From: Mark Akmenkalns [REDACTED]
Sent: 05 November 2021 16:54
To: Katherine Richards [REDACTED]
Subject: D1886 - Climping - BPC Additional Information 05-11-2021

Existing Planning & Drainage Strategy

Drawing Status	PLANNING
Client	Vivid and Climping Homes
Project	Land adjacent to Church Lane, Climping, West Sussex
Drawing Title	Proposed Drainage Sheet 1 of 4
Scale	1:500
Date	Aug. '21
Drawn By	SPB
Checked By	MJA
Drawing No.	D1886-001
Rev.	A

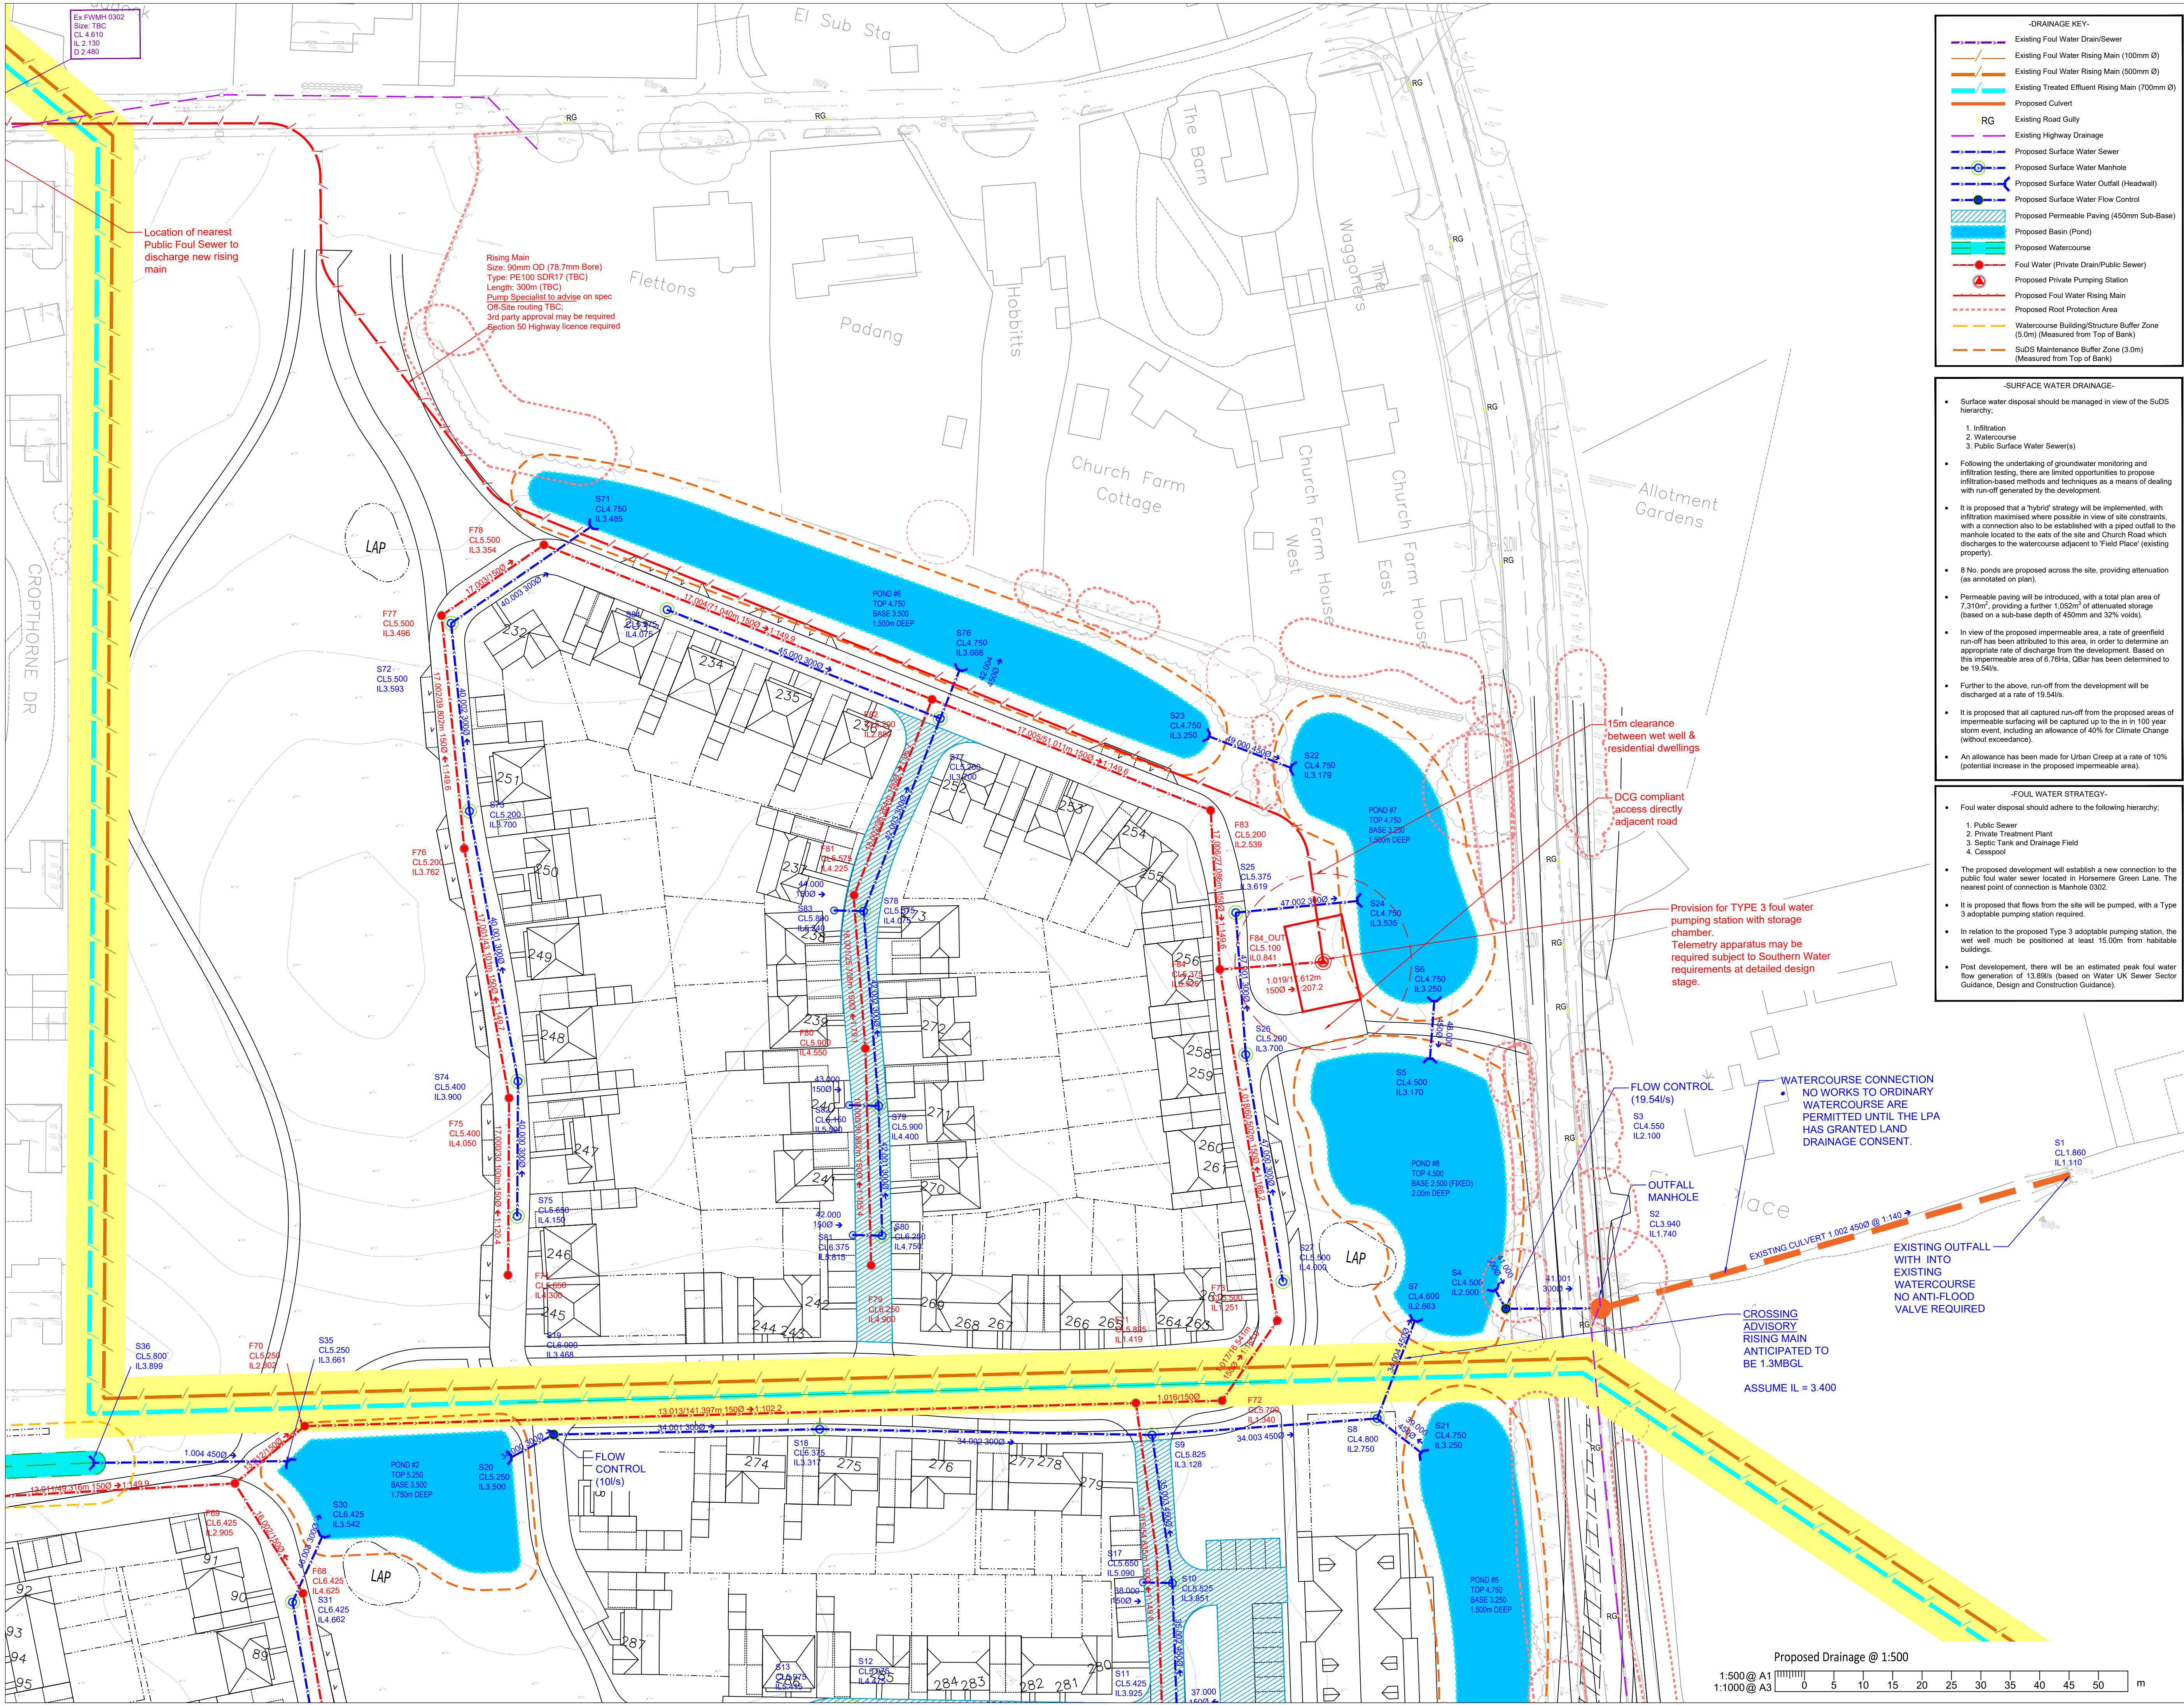
We note your comments in respect of root protection areas which I suspect you are reviewing in vicinity of the north east corner. We concur with your concerns and confirm the landscaping proposals have been coordinated to minimise any impacts and look for new planting to be set back outside the 3.0m maintenance buffers. There are a few minor conflicts, however it is understood this is addressed in the AIA report as below:

- Please see new drawing PL300 illustrating some cross sections for the ultimate storage basin (Pond 8) annotating inverts, slopes, maximum water levels and relationship to existing ground levels.
- Catchment and capacity information is summarised above.
- Flotation calculation for the ultimate storage basin (Pond 8) are enclosed. Whilst this is for Pond 8 we have considered the potential groundwater to be 1.0mbgl and so would require anchoring. This can be reviewed once we have the new data against the proposed ground levels, but in crude terms where the groundwater is likely to be shallower than 1.0m we would look to propose concrete bases at detailed design stage.
- The drainage drawings have been updated to include the RPZ areas and 3.0m buffer zones.

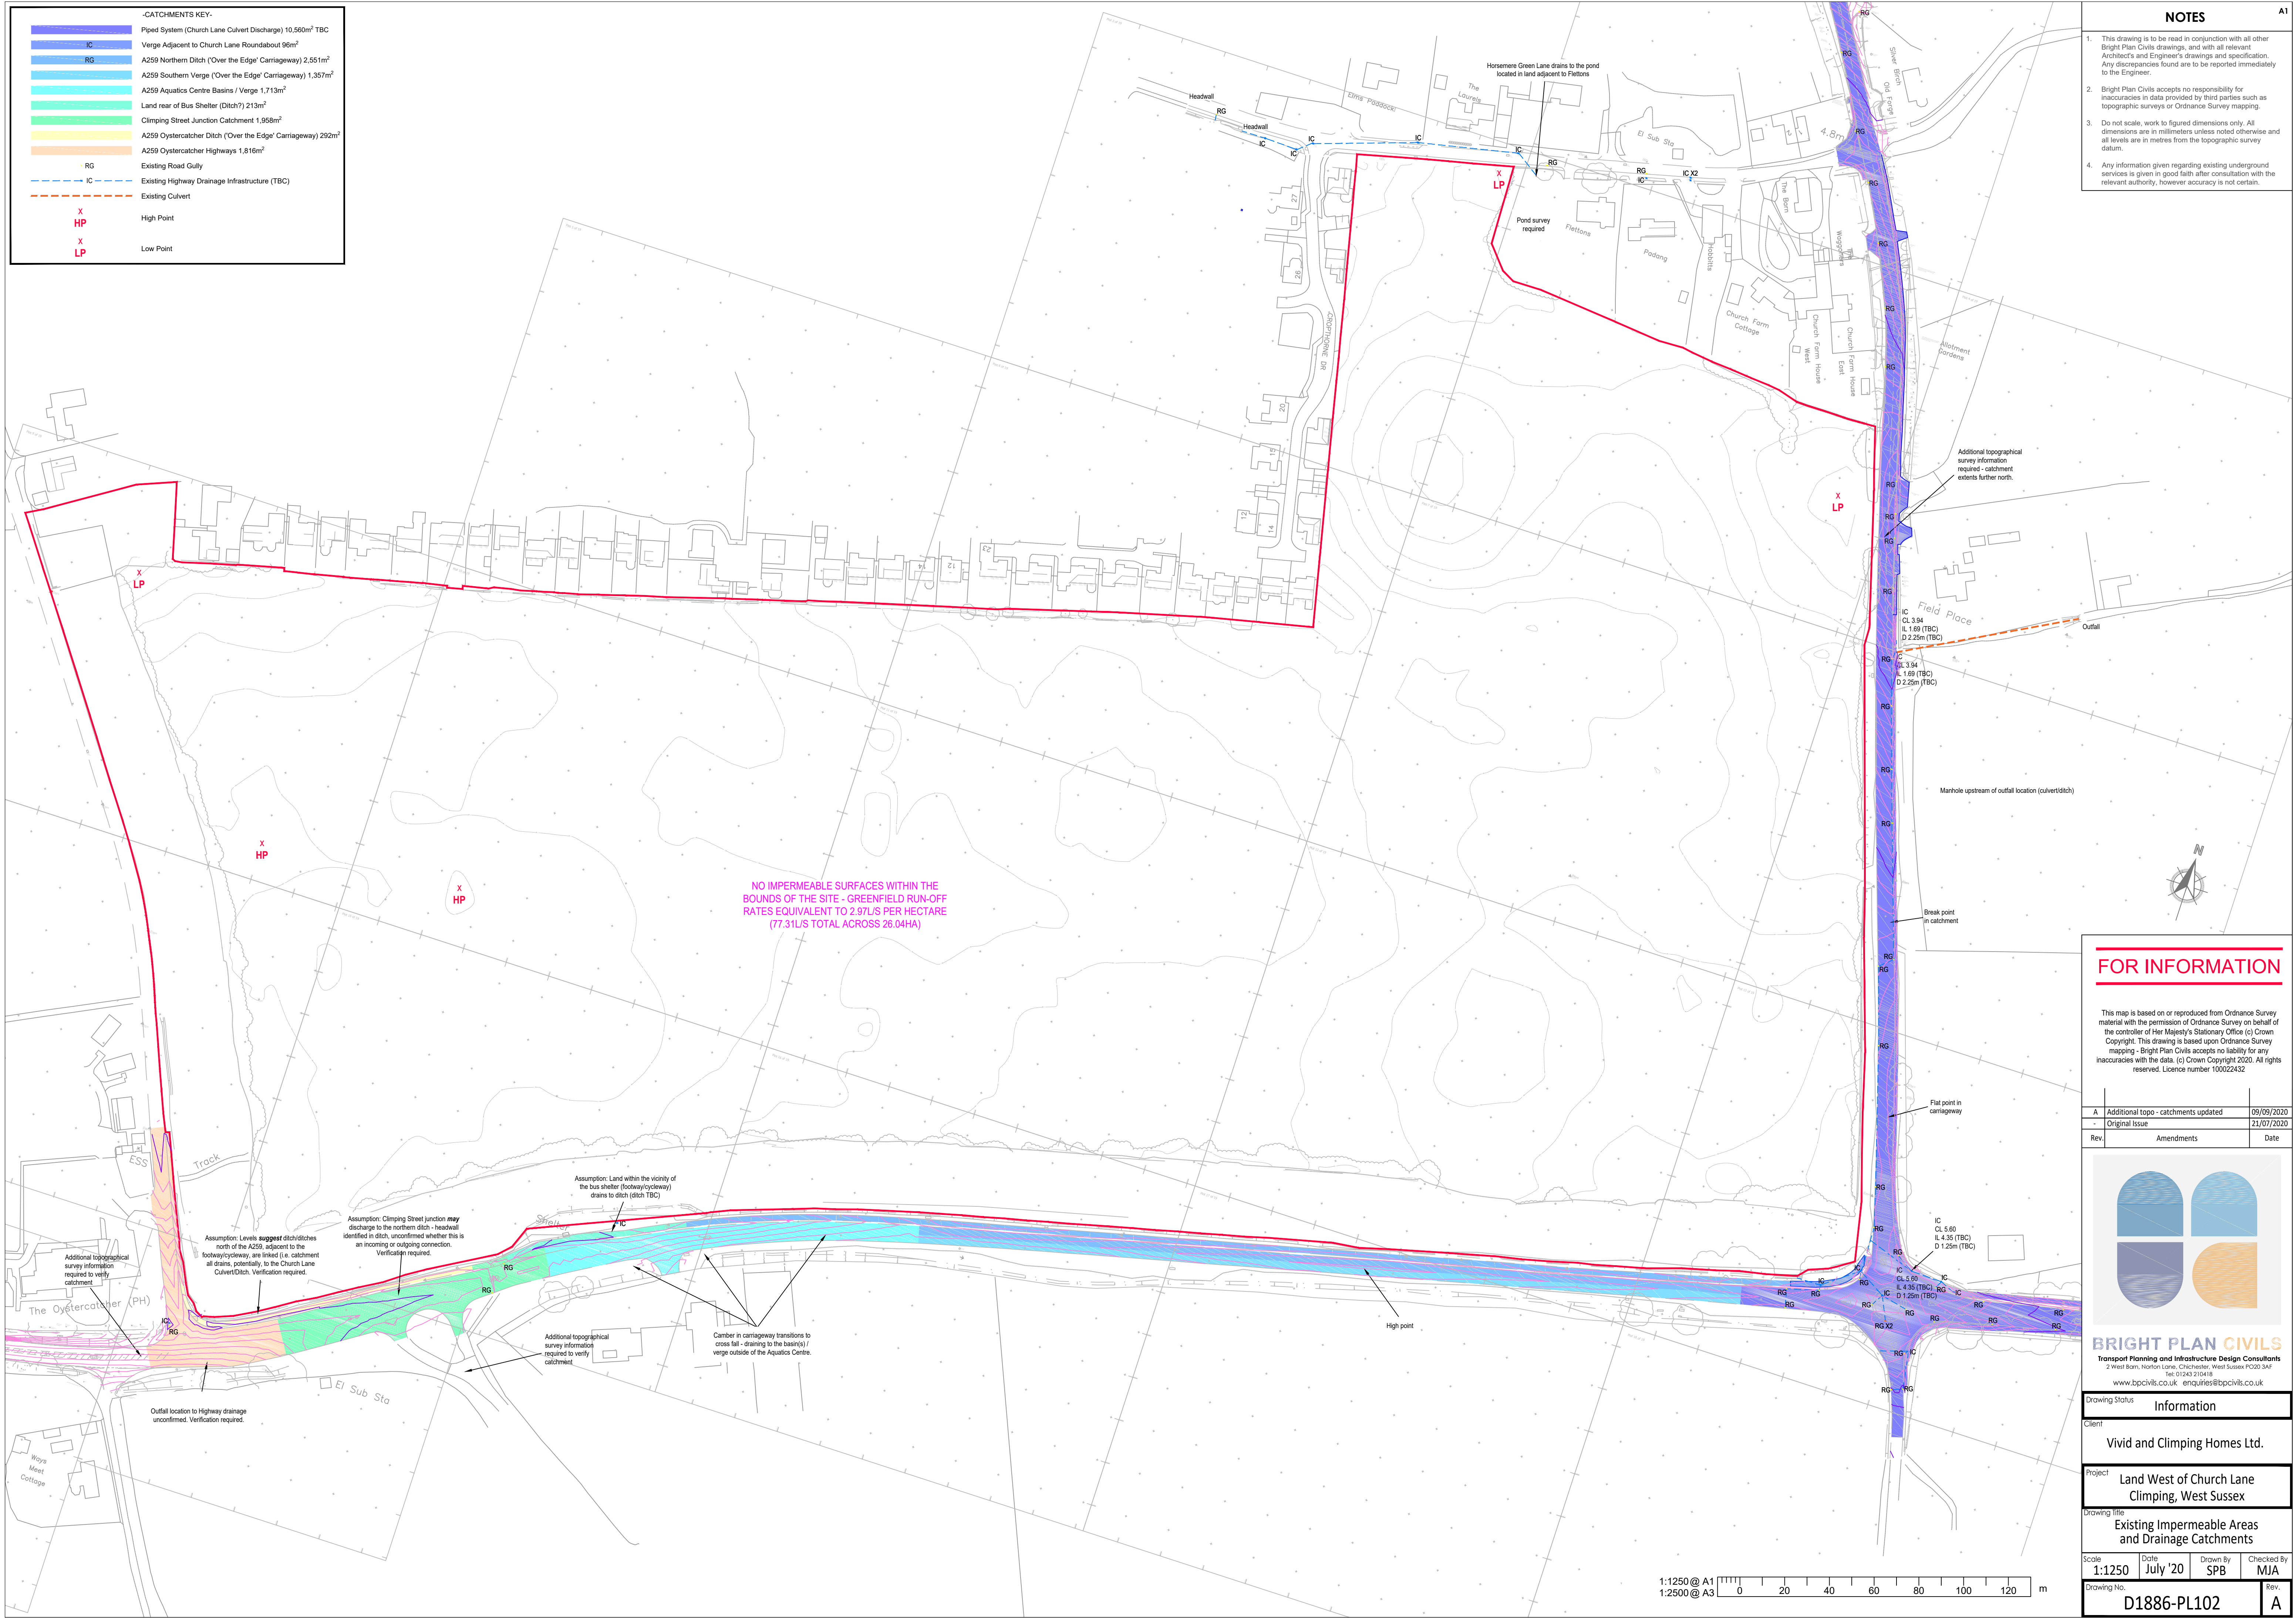
In order to gauge a better understanding of the local infrastructure, we proceeded to undertake a more thorough investigation of the local infrastructure and catchment topography. Drawing PL102, which focuses on the existing Public Highway catchment in isolation concludes a similar low point in vicinity the eastern culvert leading to the watercourse. The watercourse along the perimeter of the southern boundary collects run-off from both the site and Public Highway catchments which converge at the Church Lane roundabout and flow north towards the outfall as a 225mm diameter spine. The northern Highway drainage is routed as a 300mm diameter spine and the Highway drainage catchment appears to switch to another network approximately 100m north of the Horsemere Green Lane junction which is further clarified on new drawing PL102.1. CCTV investigations were completed whilst we were present on site and we were able to confirm a positive piped connection (450mm diameter) to the eastern watercourse exists.
